**From:** [Redacted]  
**Sent:** 12 March 2010 15:01  
**To:** Planning  
**Subject:** Welwyn Hatfield Council Online Planning - Comment

Application Number: S6/2010/0134/FP  
Name: [Redacted]  
Address: Woodhill Lodge,  
Kentish Lane  
Hatfield, Herts. AL9 6EE  
Comment Type: Object

*Twelve Apostles Church*

WOODFIELD LANE ELEVATION
PROPOSED NEW RAILINGS
1:75

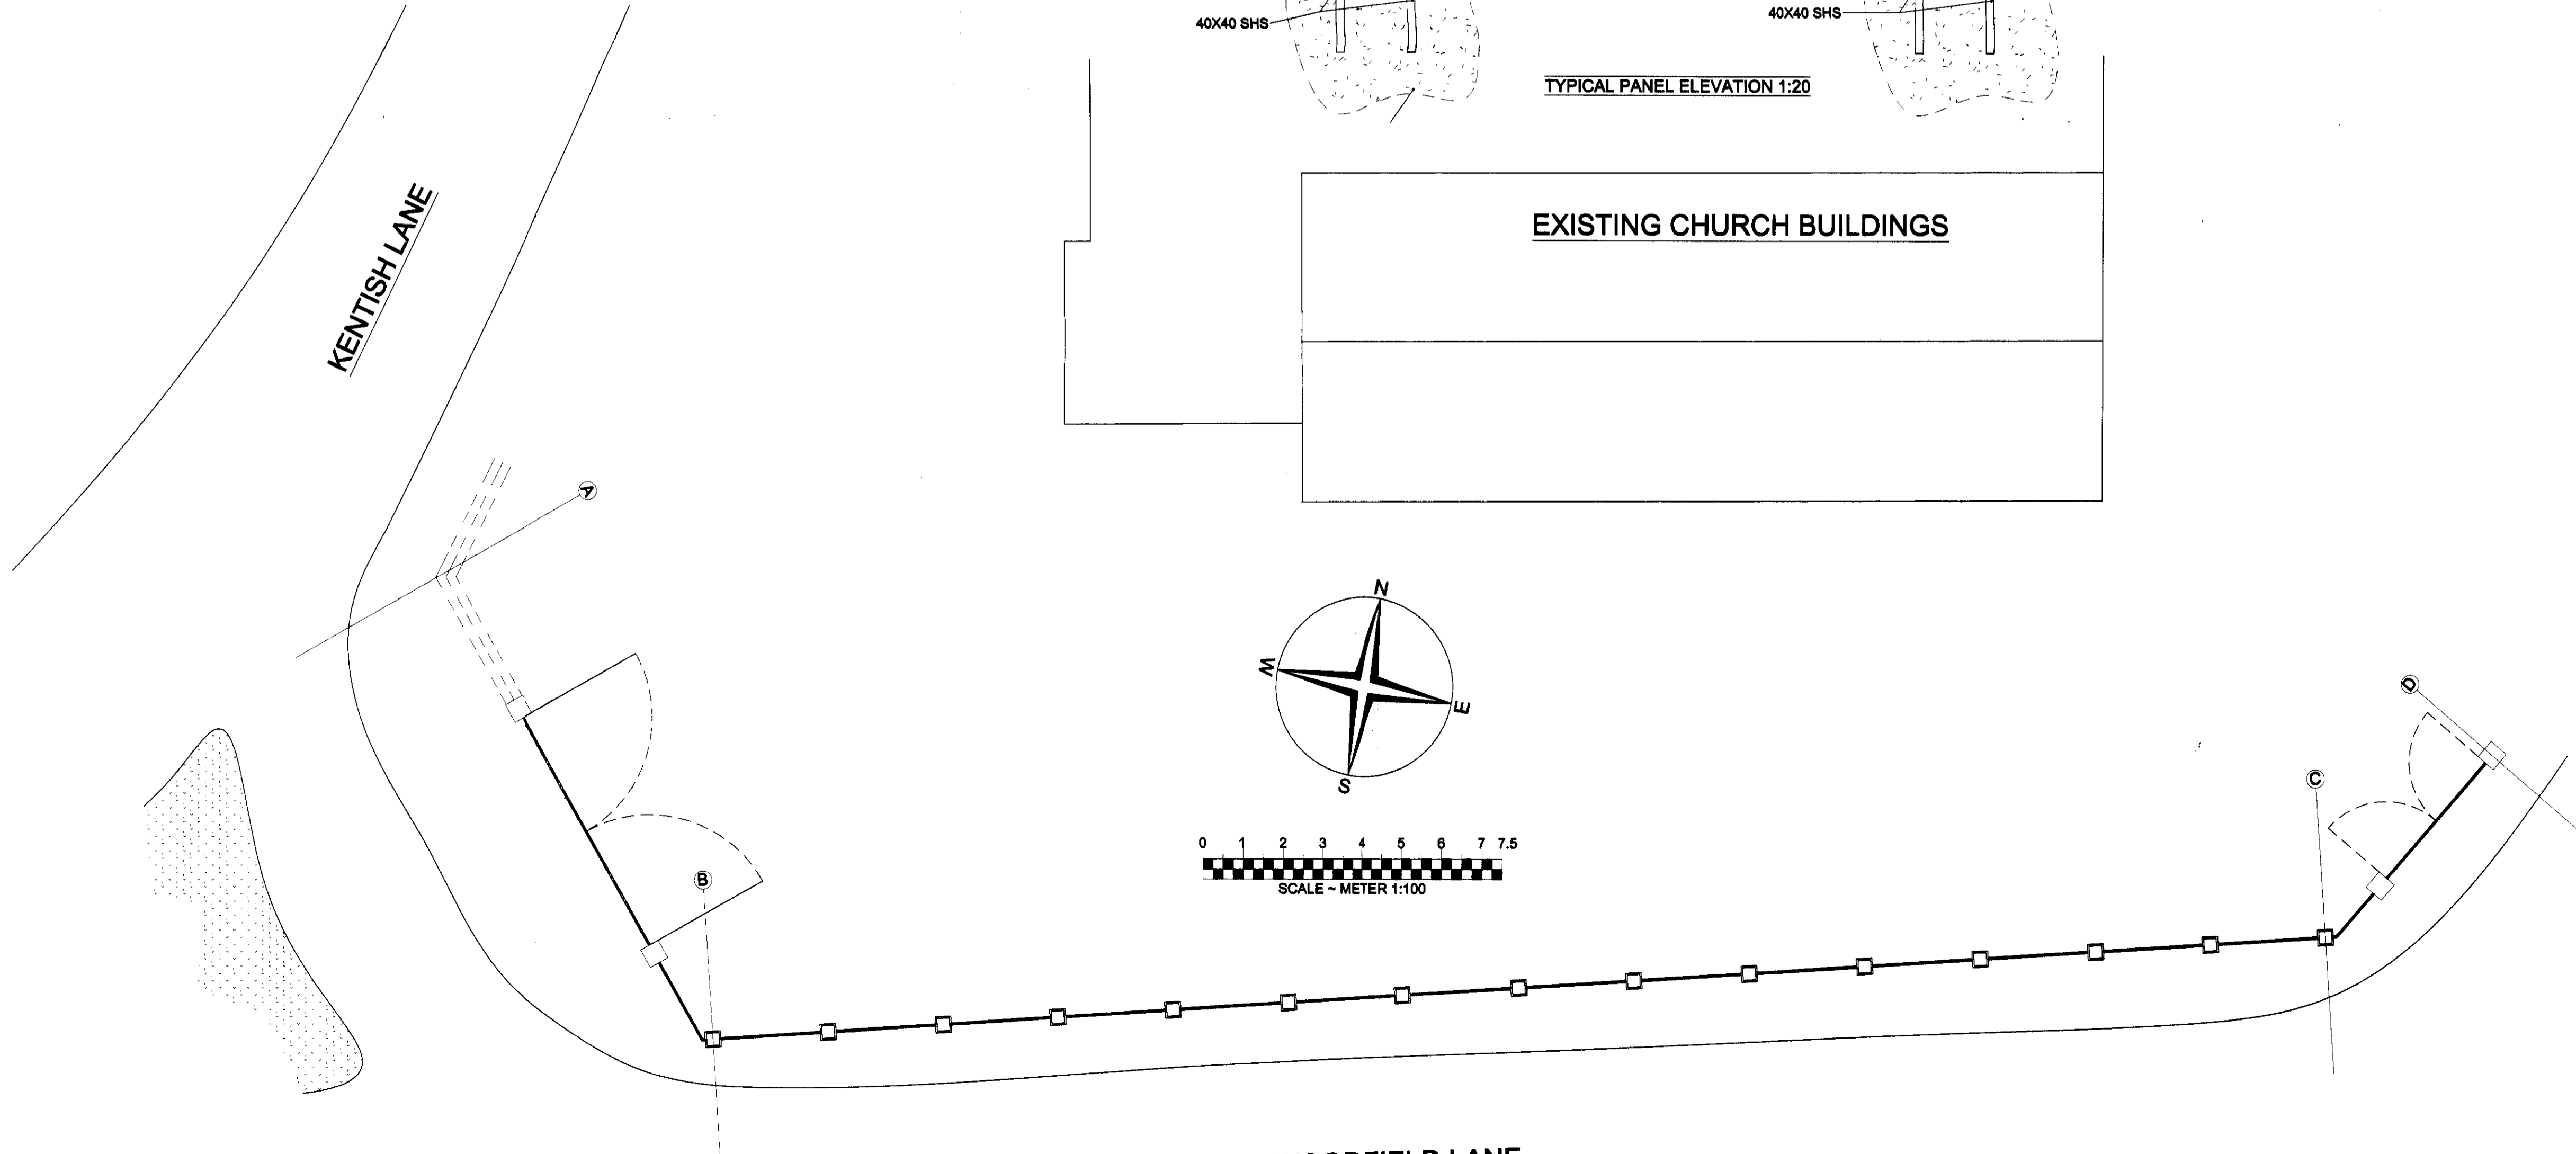
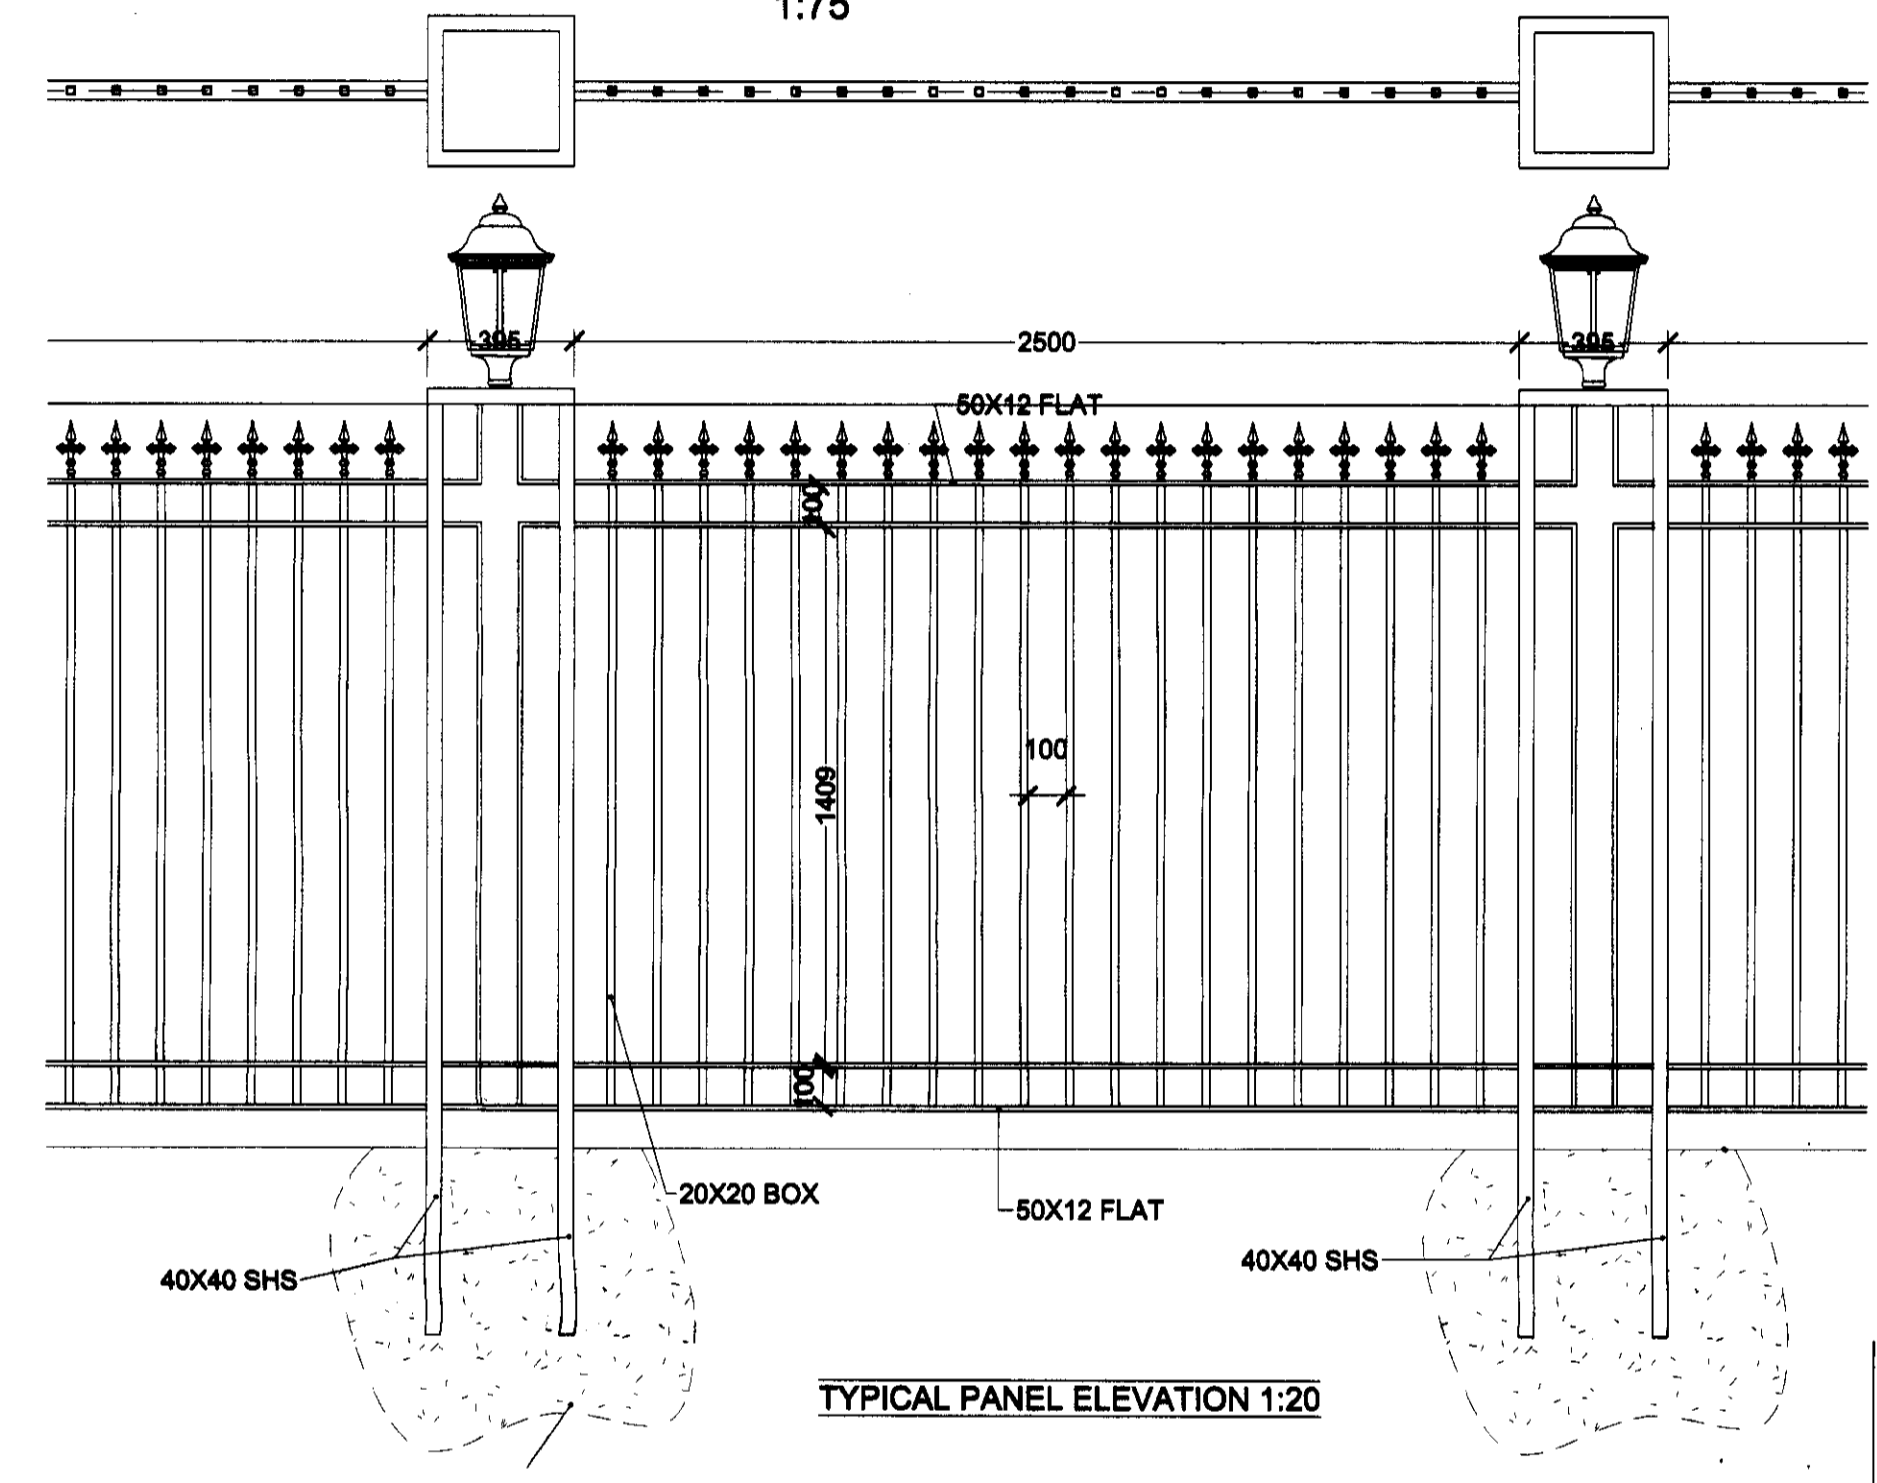
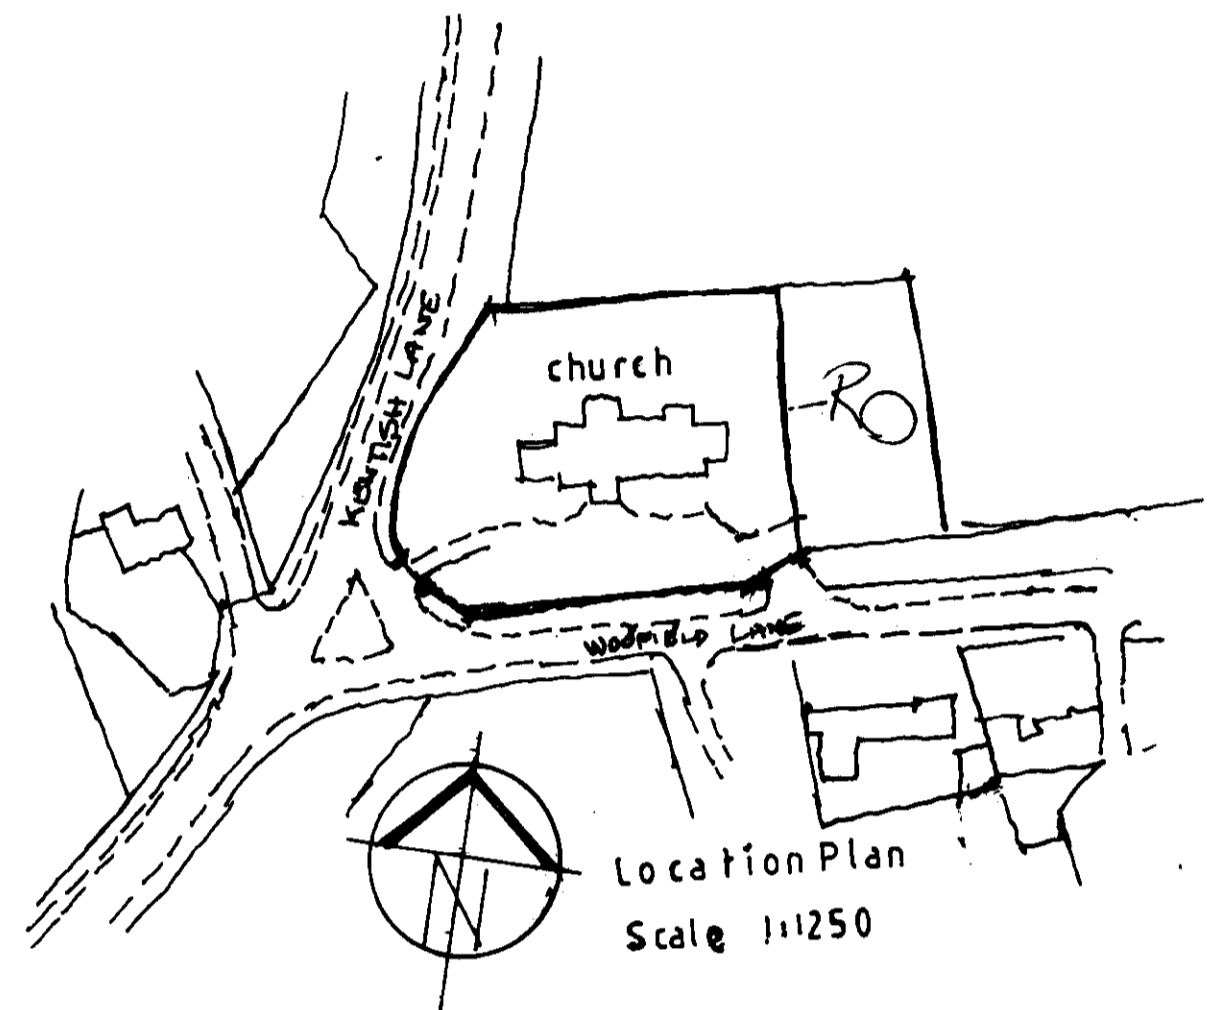
Comment: The proposed fencing looks completely out of keeping with the building and the surrounding countryside which is in the Green Belt. The building is made of flint and is the material that the current fencing is made of, which could be repaired. The lights are not necessary, the church is already well lit and has a floodlight to illuminate the car park which dazzles and confuses car drivers as they travel towards Brookmans Park along Kentish Lane. A row of unnecessary lights would cause further confusion along Woodfield Lane and would be a traffic hazard.
